Rezoning Transportation Analysis

Petition Number: 2023-154

Date	Description
12-27-23	First Review (JP)

JOB NO.  
**62387**  
SHEET NO.  
**RZ-1**

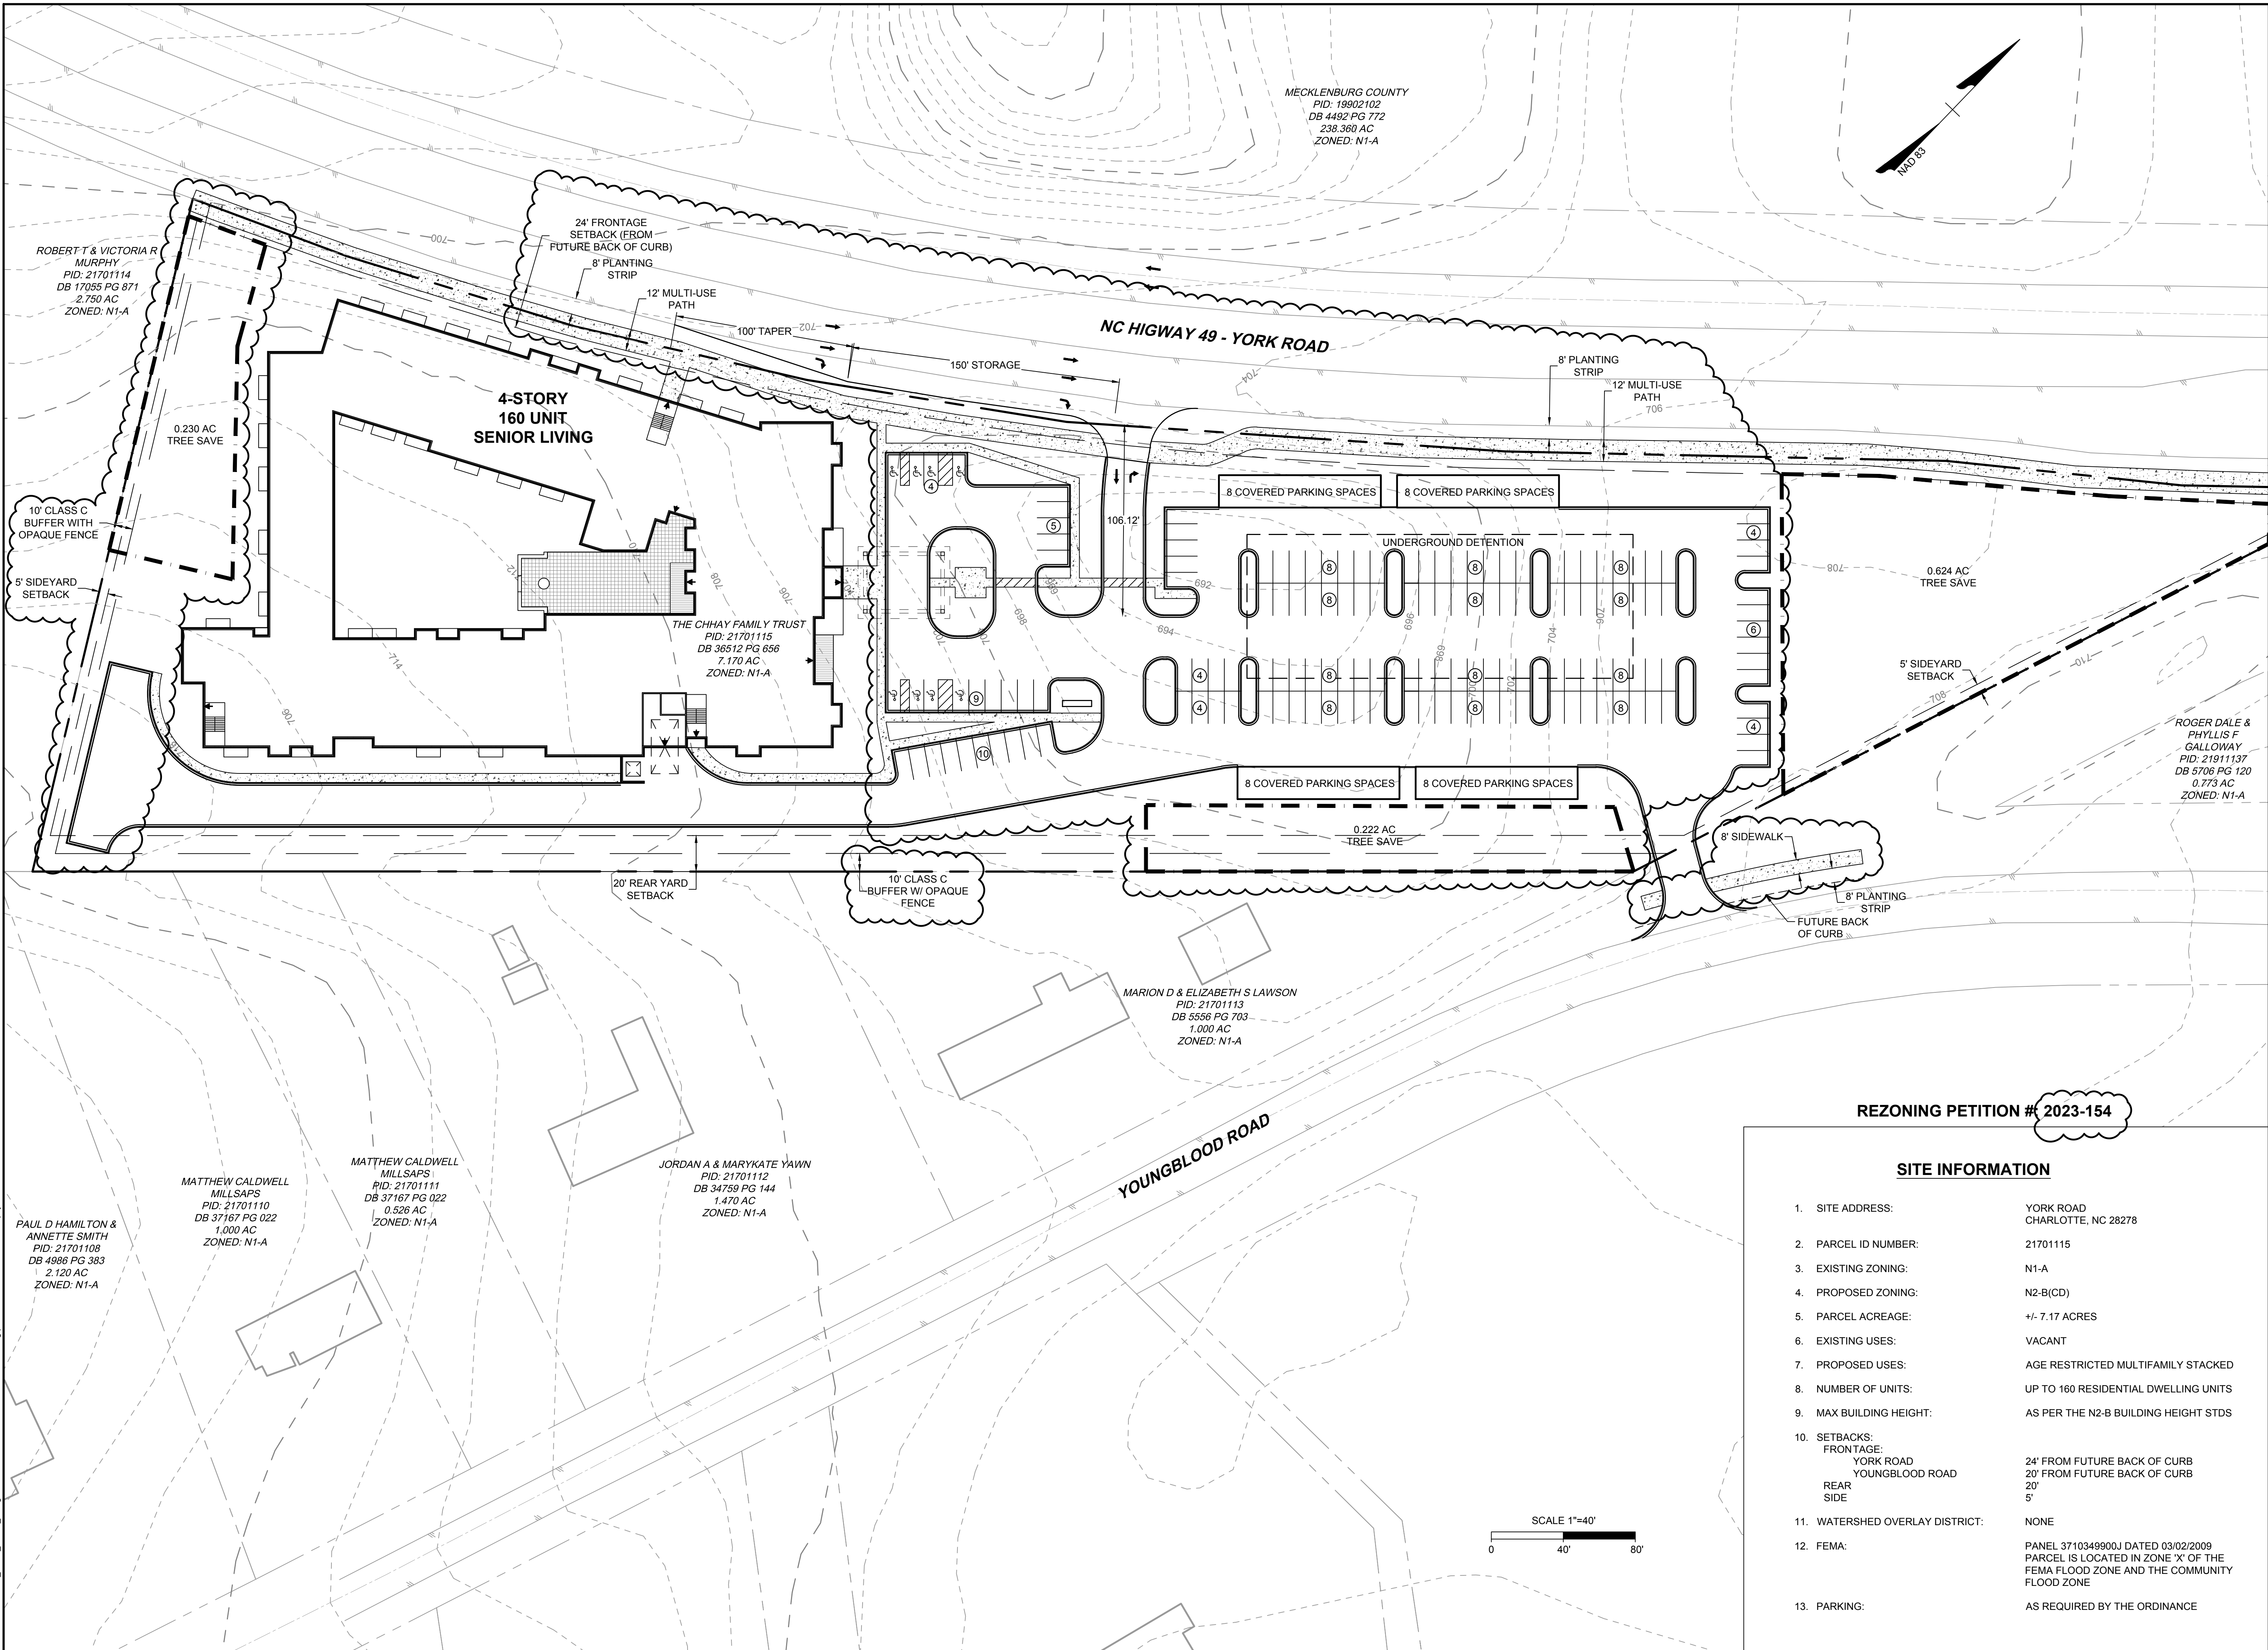
Label and dimension the curb and gutter from the centerline for each road on the site plan.

3. The site plan shall label and dimension the right-of-way from the road centerline.
4. In coordination with NCDOT, revise site plan and conditional note(s) to show the existing driveway on the east side of Youngblood Road. Align the sites entrance along the centerline of the existing driveway.
5. Revise site plan and conditional note(s) to restripe a left turn lane into the site off of Youngblood Road.

6. In coordination with NCDOT, revise site plan to remove western most site access.

7. In coordination with NCDOT, revise site plan and conditional note(s) to install a right turn lane on York Road with 150' storage and 100' taper.

8. In coordination with NCDOT, revise site plan and conditional note(s) to provide a 100' internal protected stem.

11. Revise site plan and conditional note(s) to construct 8-foot planting strips and 12-foot multi-use paths on York Road and Youngblood Road. The site plan shall label and dimension both items from the back of curb and gutter or edge of pavement. Add conditional note The entire facility must be outside of the right of way and within a public access easement. Add conditional note committing to construction and maintenance of the 12-foot multi-use paths on York Road and Youngblood Road.
